# Consultee Comments for Planning Application 23/06673/FU

Application Number: 23/06673/FU

Address: 48 Millbeck Green Collingham Wetherby LS22 5AJ

Proposal: Retrospective application for new gates to front

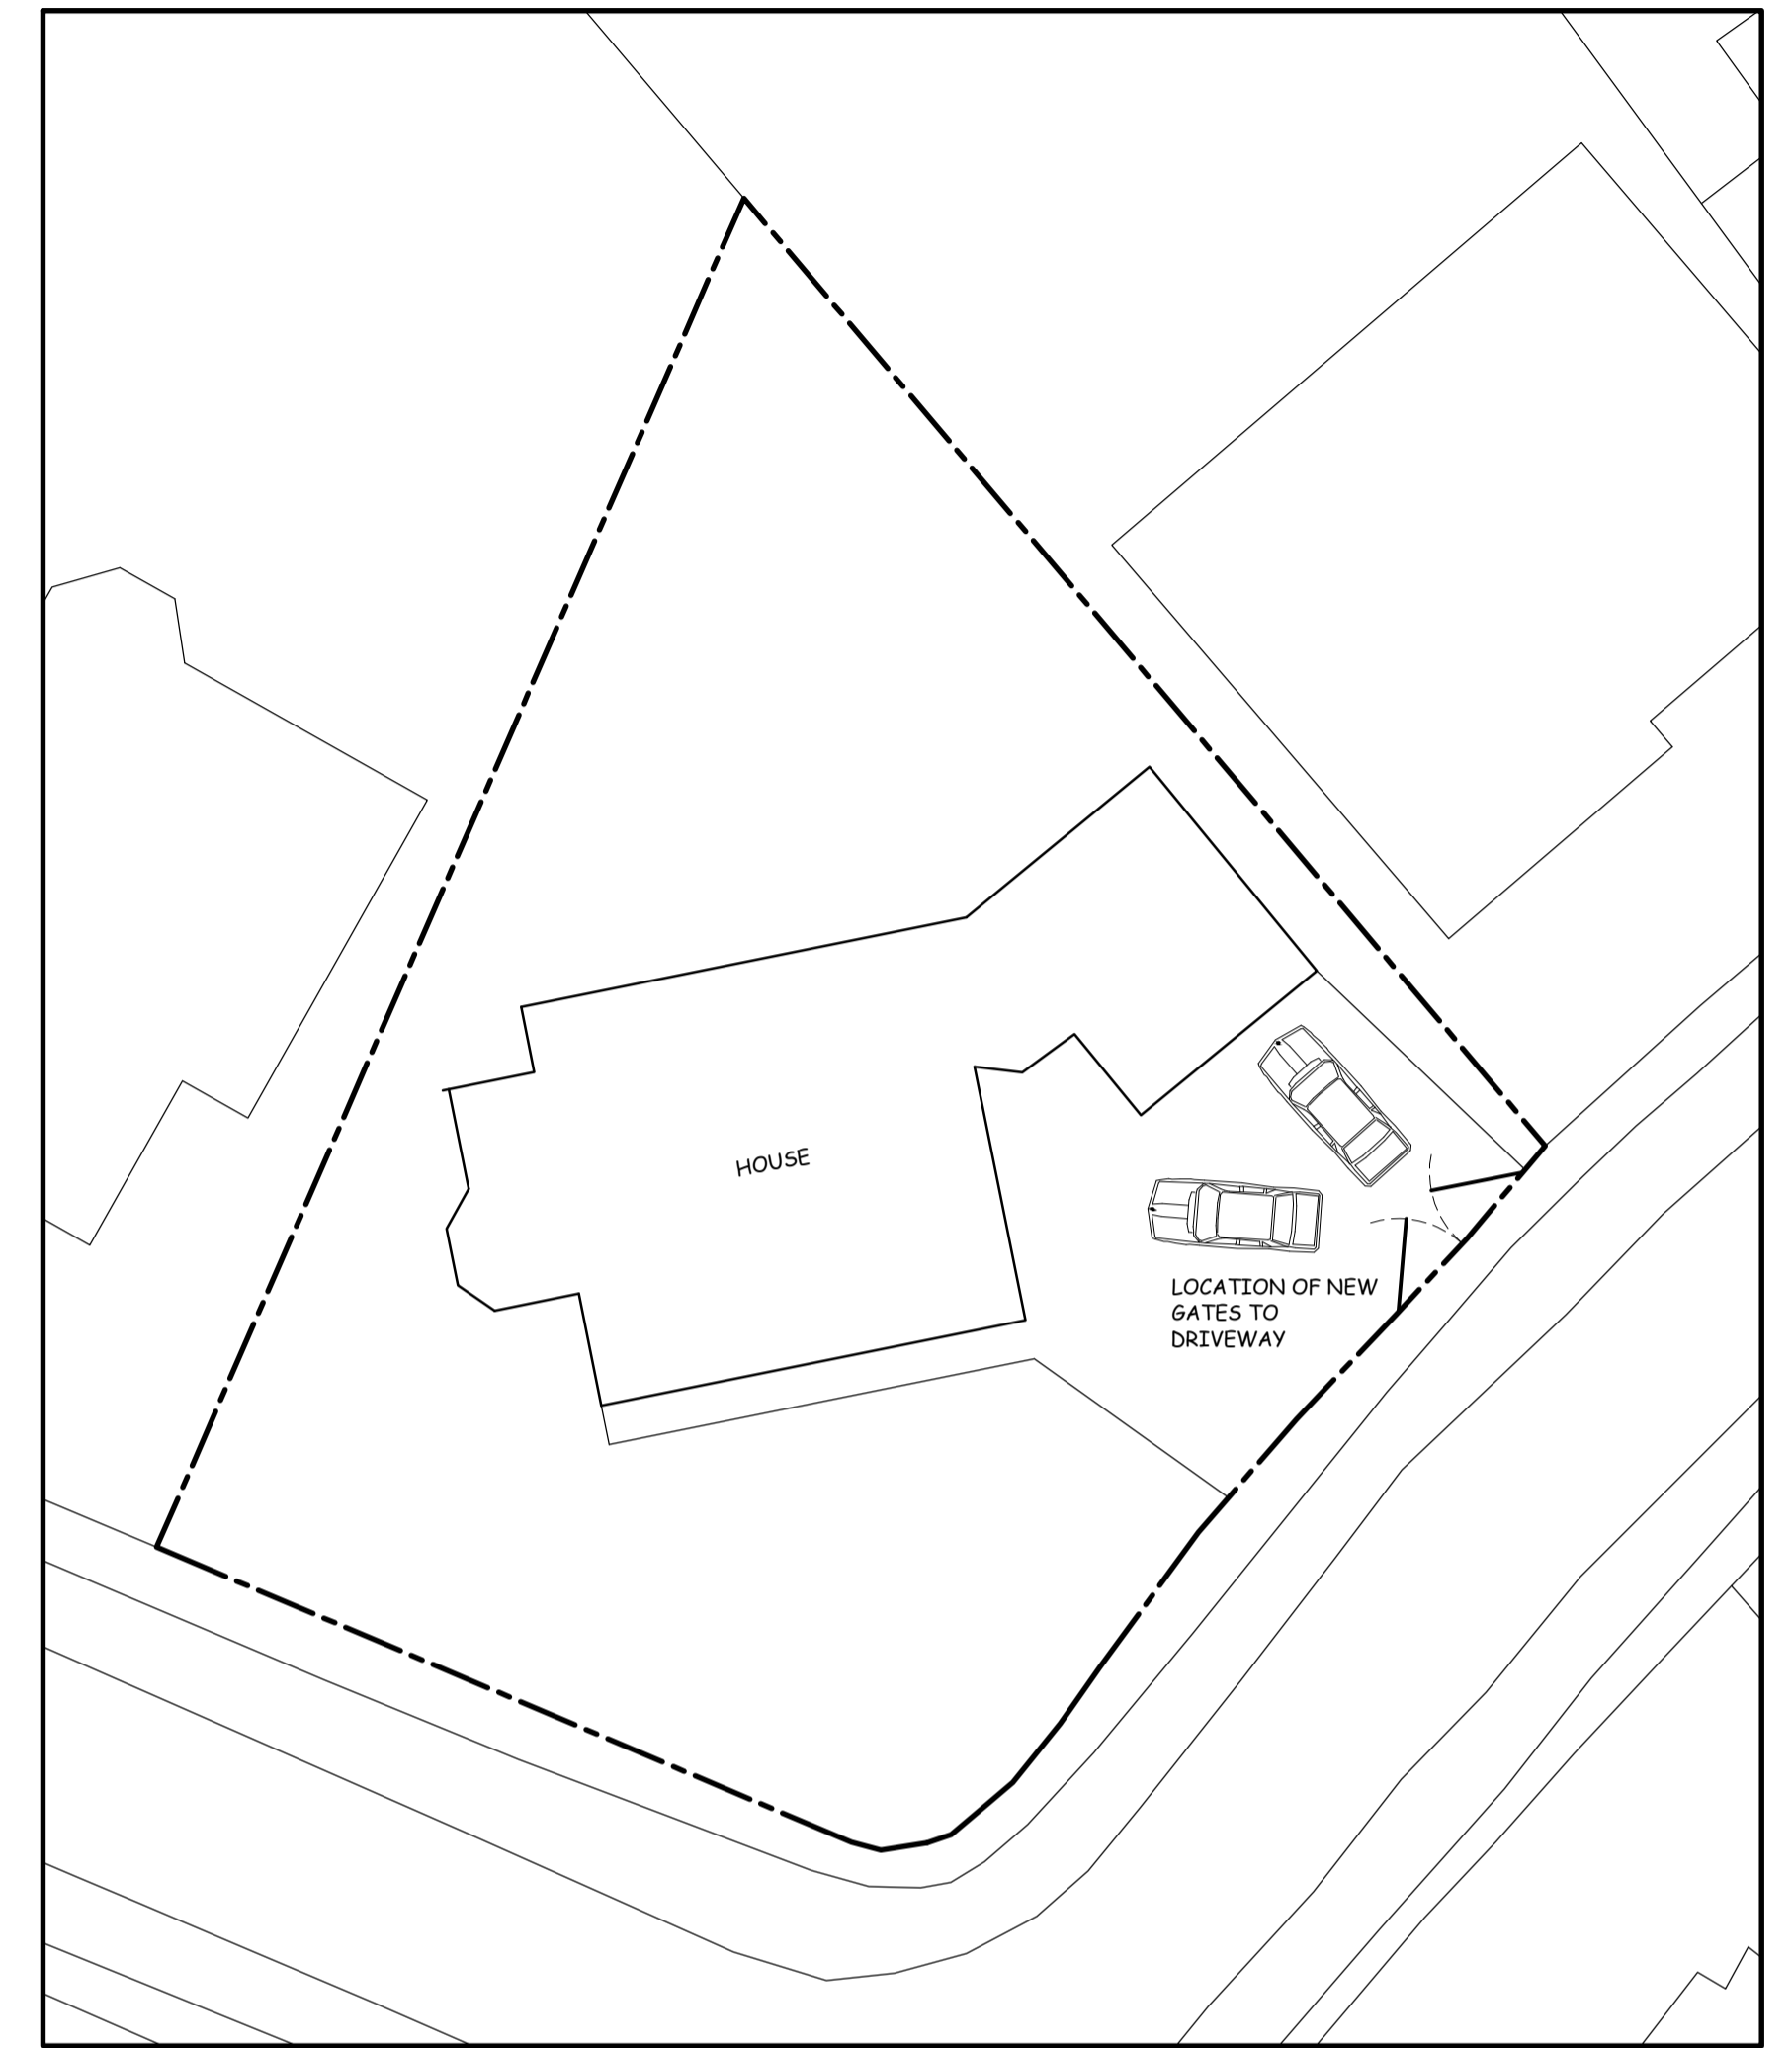
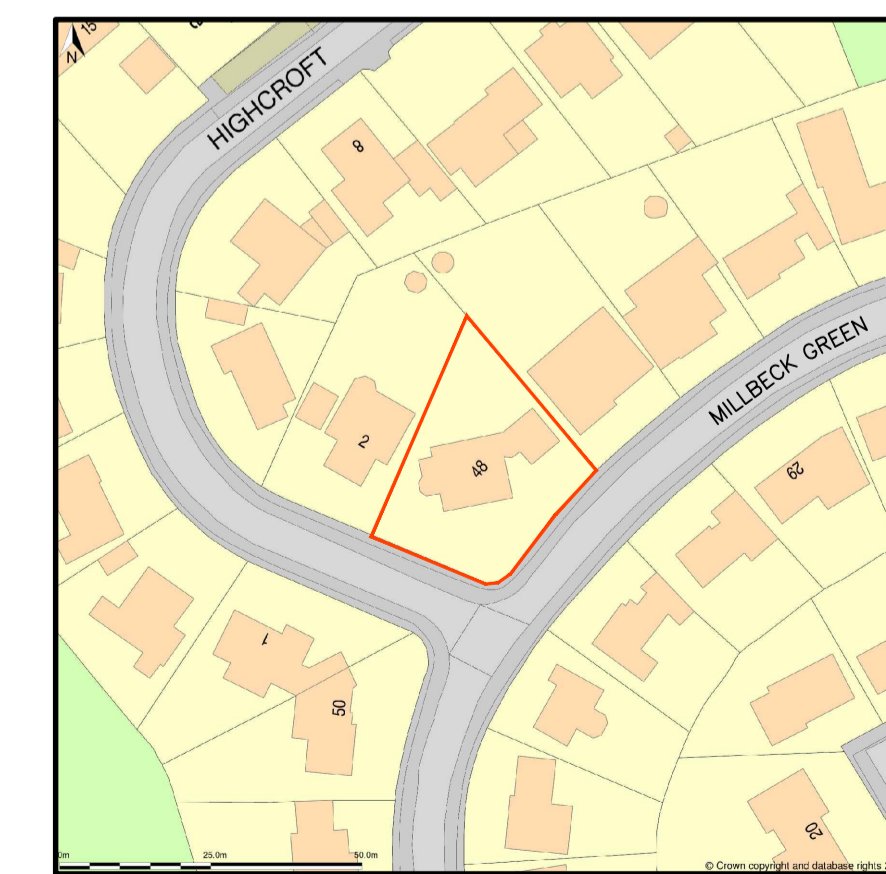
Collingham with Linton Parish Council is mindful of the special circumstances of the applicant, but on purely planning terms the new gates should be refused on the grounds that they are not in keeping with the immediate surroundings nor the wider Millbeck Green estate.

One of the most important characteristics of the area is the openness of frontages and this style of enclosure is damaging to this characteristic. The neighbourhood plan makes reference to this.
